Byers Gill Solar EN010139

3.3 DCO Schedule of Changes

Change Application - October 2024

Revision 2

Drawing Title  
**Street Works, Public Rights of Way & Access Plans**  
Sheet 3 of 13  
**APFP Regulation 5(2)(k)**

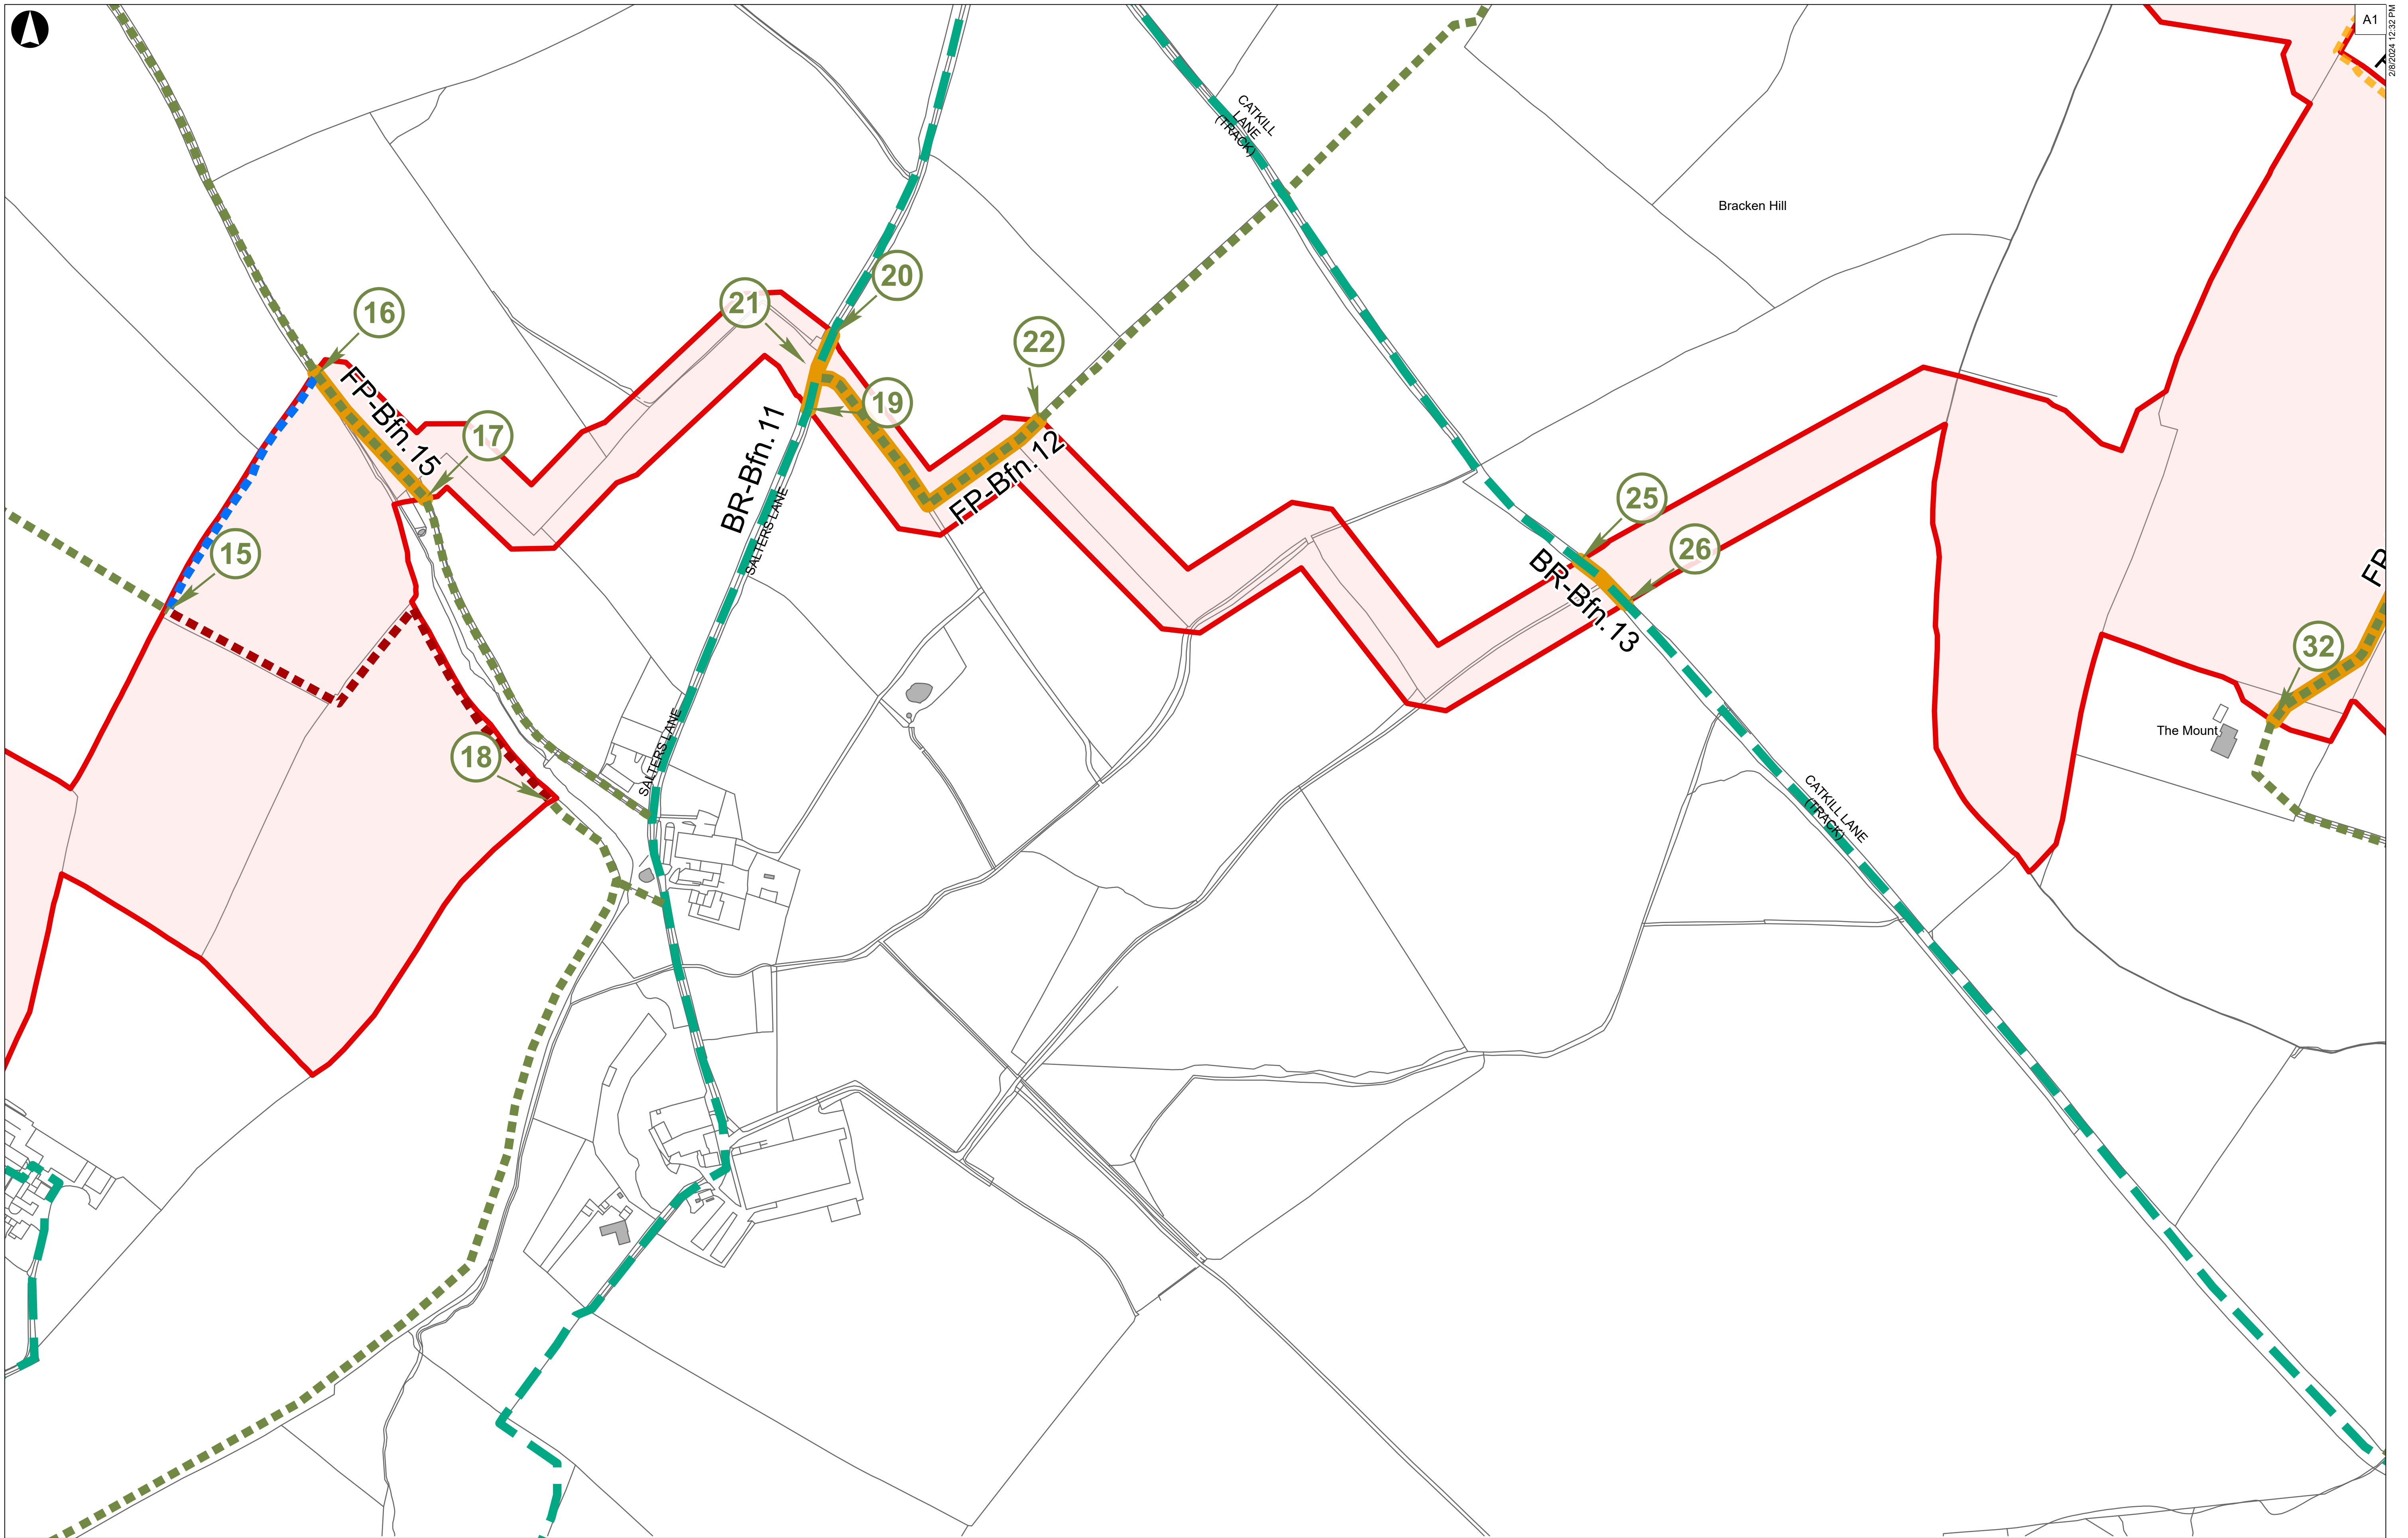
For	example,	row	2 of	the	table	has	been	amended a	as
follo	ows:

Parish of	Unnamed	Cable works beneath the
Brafferton	Road	width of highway <u>street</u> comprising a length of
		320m as shown between points marked A and B on sheet 3 of the street works, public rights of way and access plans.

Sheet 9 of 13

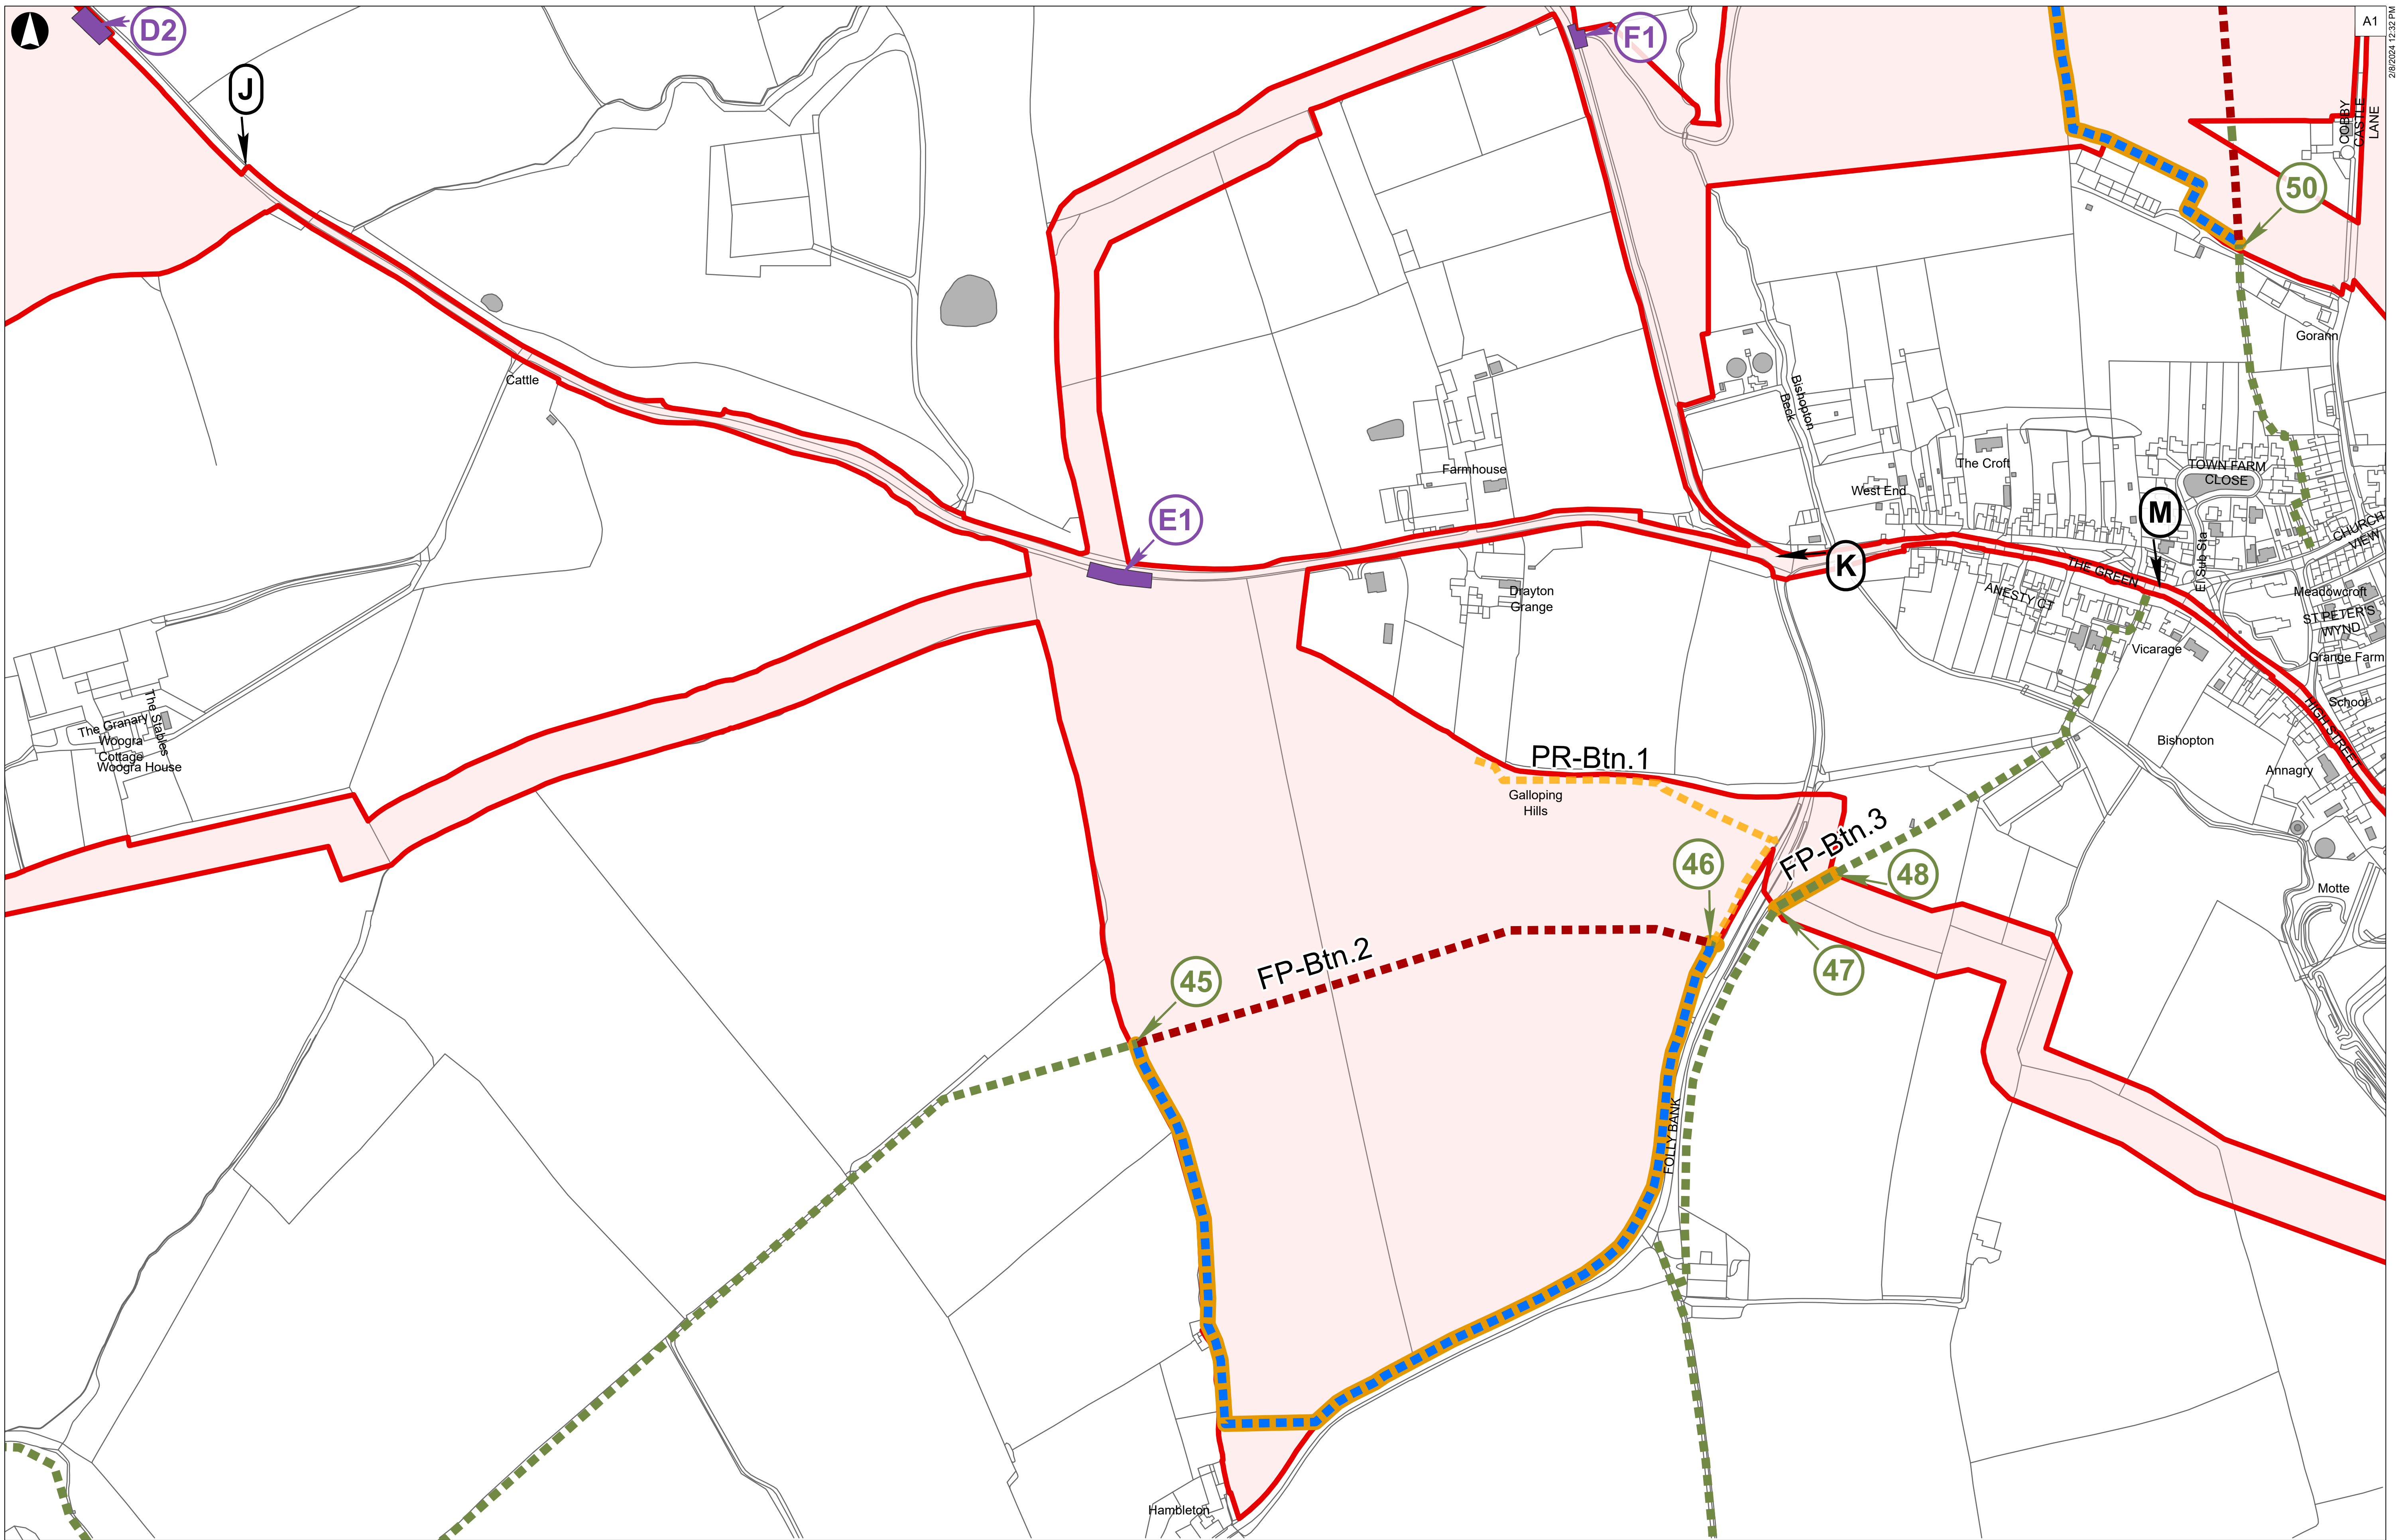
Within the table of street works in Schedule 3, two rows have been added as follows:

Parish of Bishopton	Folly Bank	Cable works beneath the width of street as shown with reference CC5 on sheet 9 of the street works, public rights of way and access plans.
Parish of Redmarshall	Redmarshall Road, in the vicinity of Morrington Bridge	Cable works beneath the width of street as shown with reference CC6 on sheet 11 of the street works, public rights of way and access plans.

These two rows have been added to provide street works descriptions for two locations where the Applicant proposes to carry out cabling works across the width of a street for the purpose of delivering the off-road cable route. These descriptions are included as a correction to Revision 1 of the dDCO.

Corresponding amendments have been made to the Street Works, Public Rights of Way and Access Plans to indicate these locations.
